February 6, 2024

Site: 7414 78th Ave SE  
Mercer Island, WA 980404  
TPN: 2524049075  
Area: 68,825 sq. ft. = 1.6 acre

Re: RFI dated November 27th, 2023, changes itemized below, on the report and on the city response matrix highlighted in yellow.

Comments on Trees:

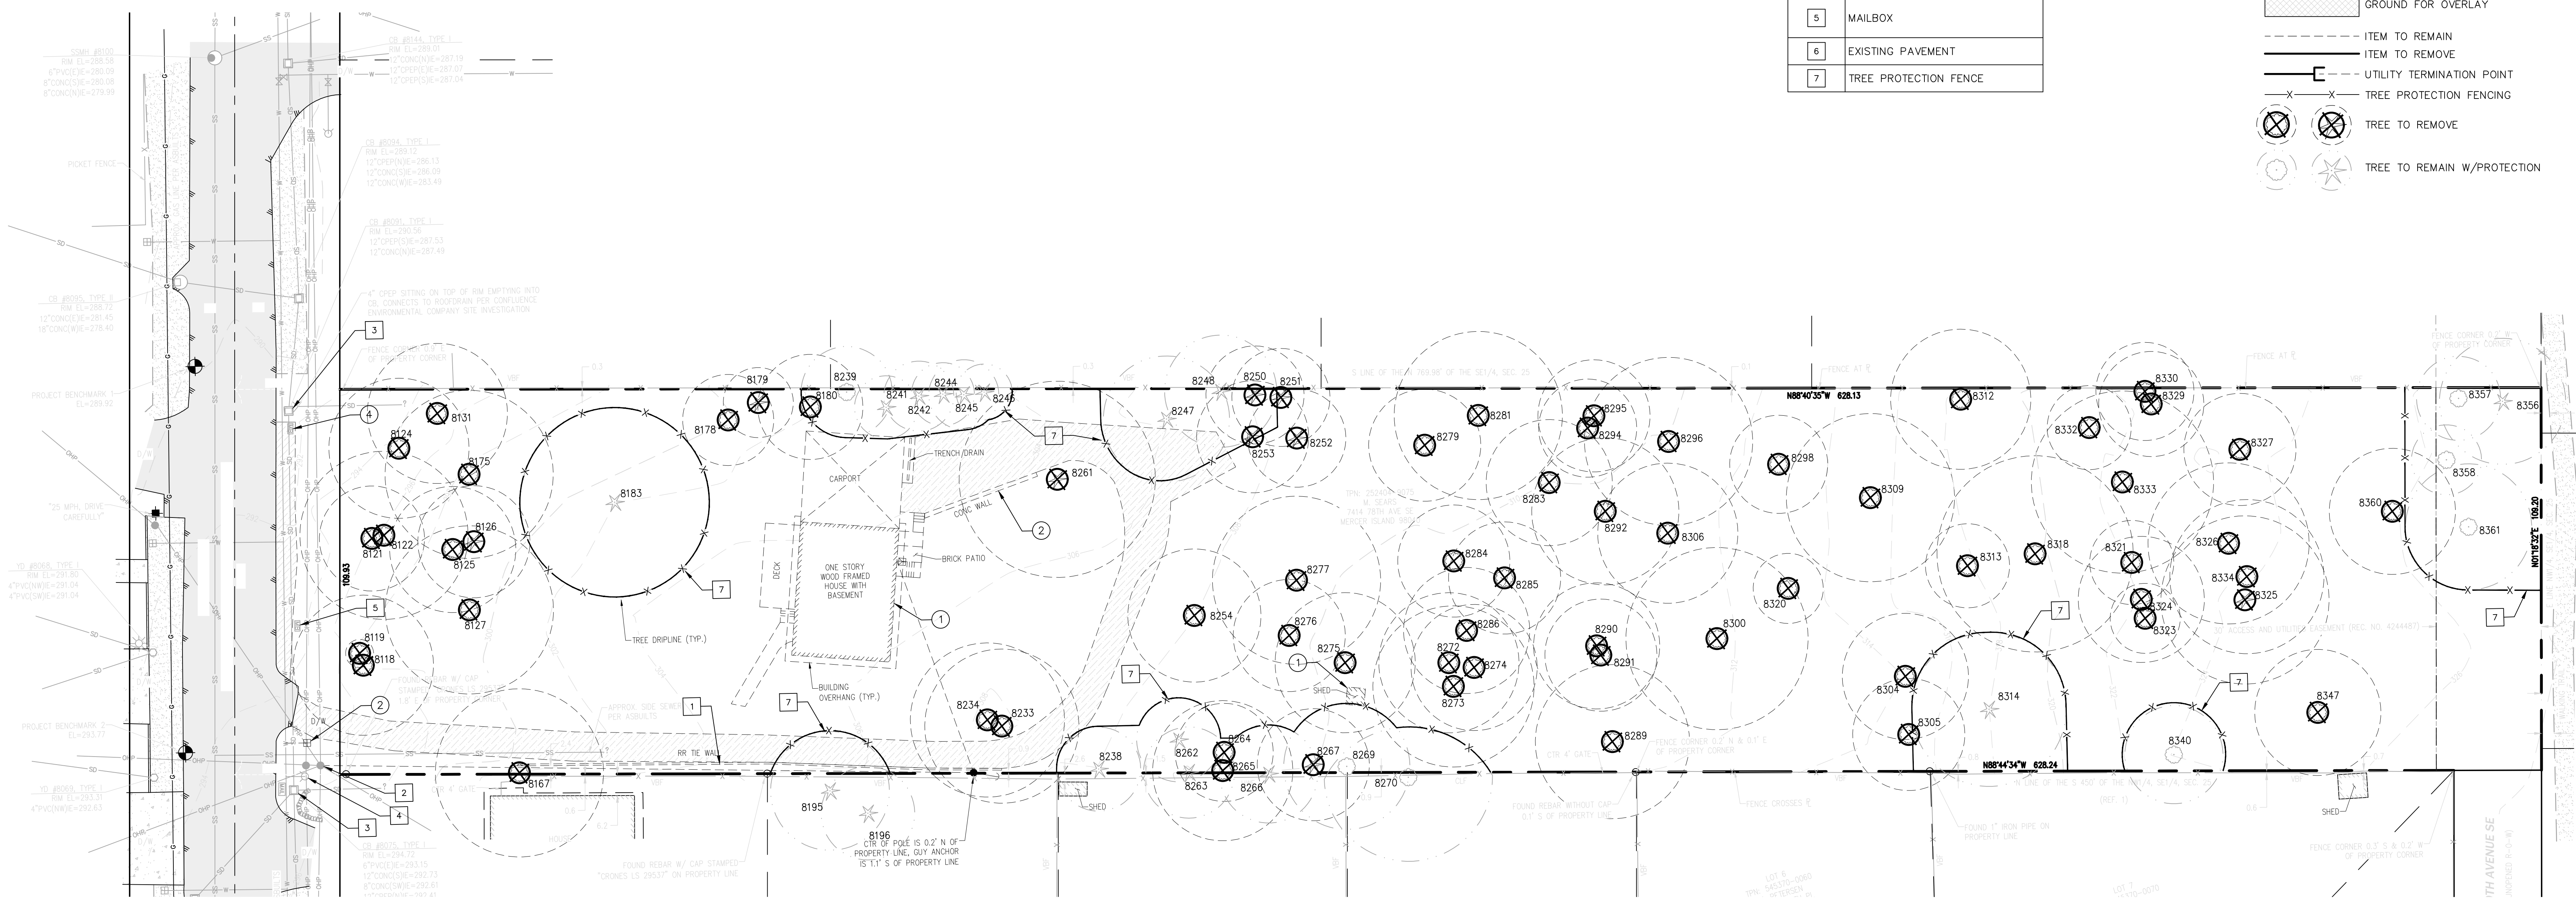
1. The tree protection shown on the site plan is right on the building pad, which would be unrealistic in the field. The building pads will need at least five feet of clearance for walking and machine access. The tree protection and limits of allowable disturbance will need to be adjusted to account for the five-foot clearance. (Building pads were reduced to allow for a 5' buffer, completed by Navix; site plan is copied and pasted onto page 21)
